Item No. **Report of the Head of Planning, Transportation and Regeneration**

Address CHERRY LANE CEMETERY SHEPISTON LANE HAYES

Development: A 2.5m extension to the existing 22.5m lattice tower, the removal of six antennas and the installation of twelve antennas, twenty-four Remote Radio Units (RRUs), additional ancillary apparatus and the relocation of three transmission dishes.

LBH Ref Nos: **35298/APP/2021/3325**

DRG No.	Sheet 1 of 2	Rev
1490106-06-153-MD024	24

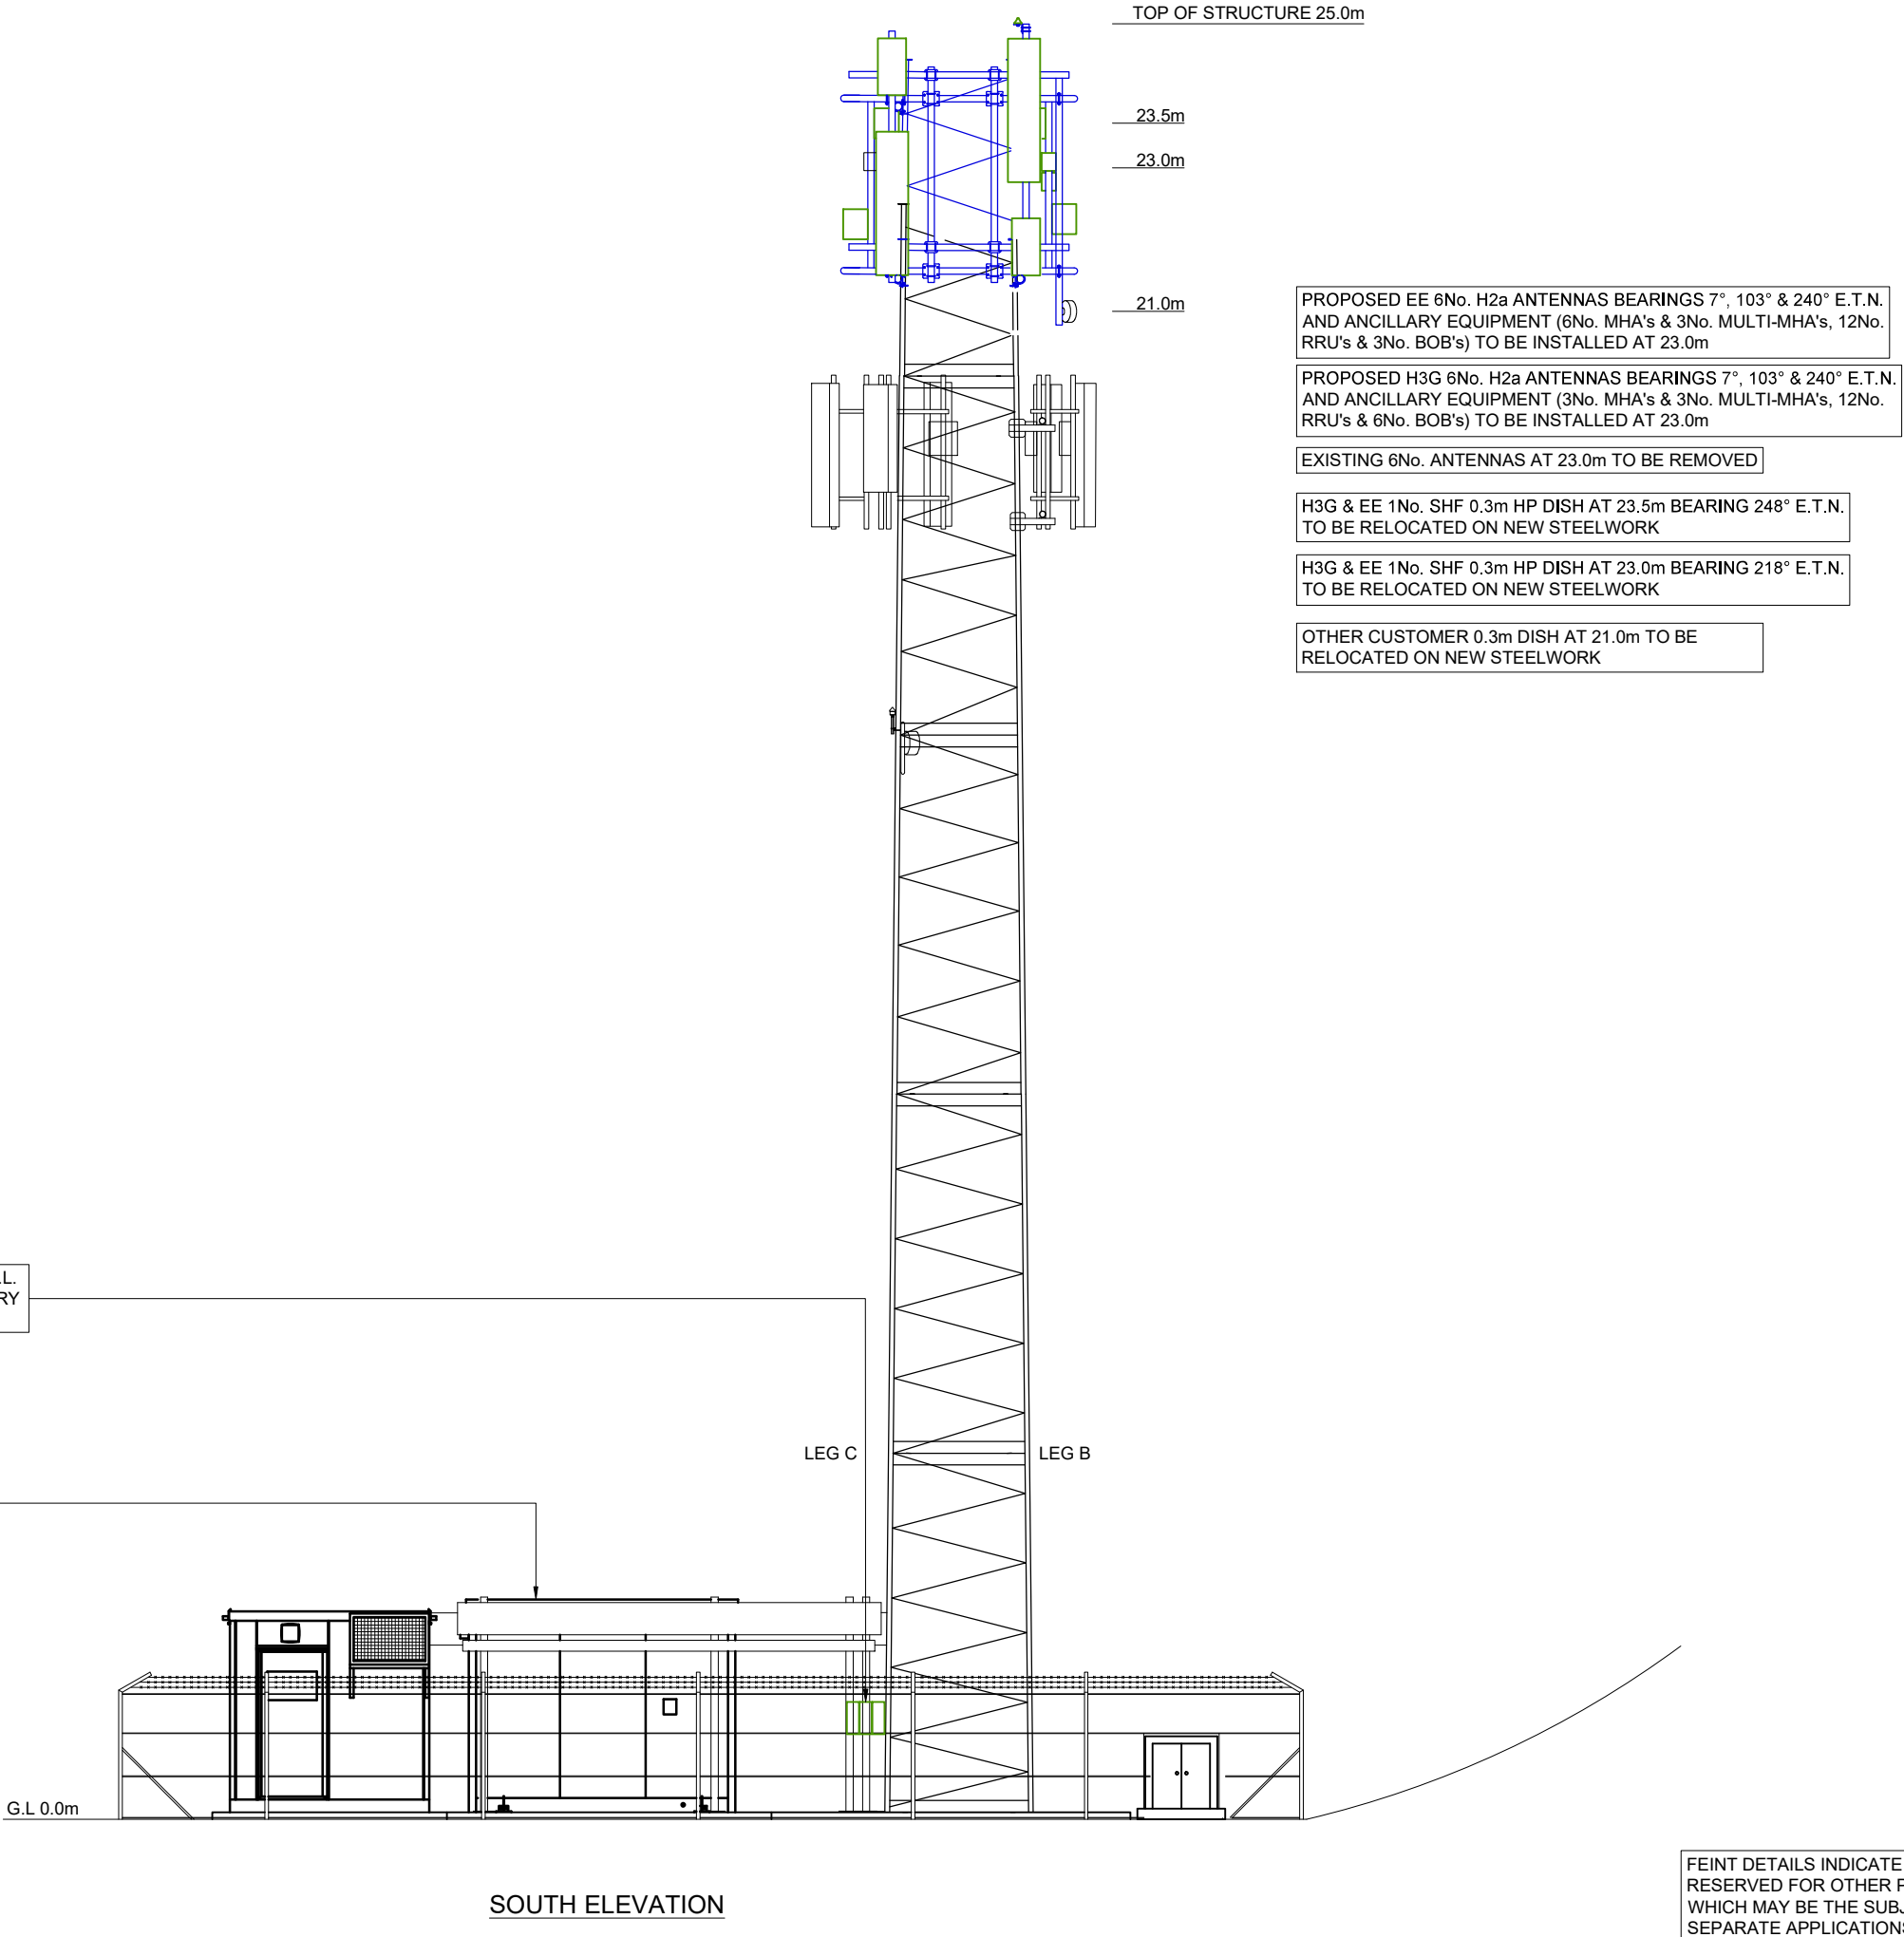
The proposed extension to the telecommunications lattice tower and associated equipment would, by virtue of their siting, size, scale, bulk and height, represent a visually dominant development that would harm the open character of the green belt and wider area. The development would therefore be contrary to paragraph 115 and Section 13 of the National Planning Policy Framework (2021), Policy G2 of the London Plan (2021), EM2 of the Hillingdon Local Plan: Part One - Strategic Policies (2012) and Policies DMHB 21 and DMEI 4 of the Hillingdon Local Plan: Part Two - Development Management Policies (2020).

The proposal is an alteration to an existing lattice tower, an extension by 2.5m and the installation of an extra 6 antennas to what is existing (removal of 6, installation of 12 new). The proposal lies to the northern end of the Cherry Lane Cemetery, in an area of a large open expanse of landscaped lawns for quiet contemplation. Given the siting shown on the proposed plans it is noted that the surrounding trees would act as a natural green screen from the ground level telecommunications equipment. However, there would still be a significant portion of the development viewable above the existing tree line. The lattice tower itself would increase in height by over 11 percent. However, it is the combination of the additional antennas (double the existing) and radio units (24) at the top of the tower that would harmfully increase the visual bulk of the development, adversely affecting the open character of the Green Belt and cemetery.

This is considered to be a disproportionate addition to the lattice tower, which in accordance with paragraph 149 of the NPPF, is inappropriate development.
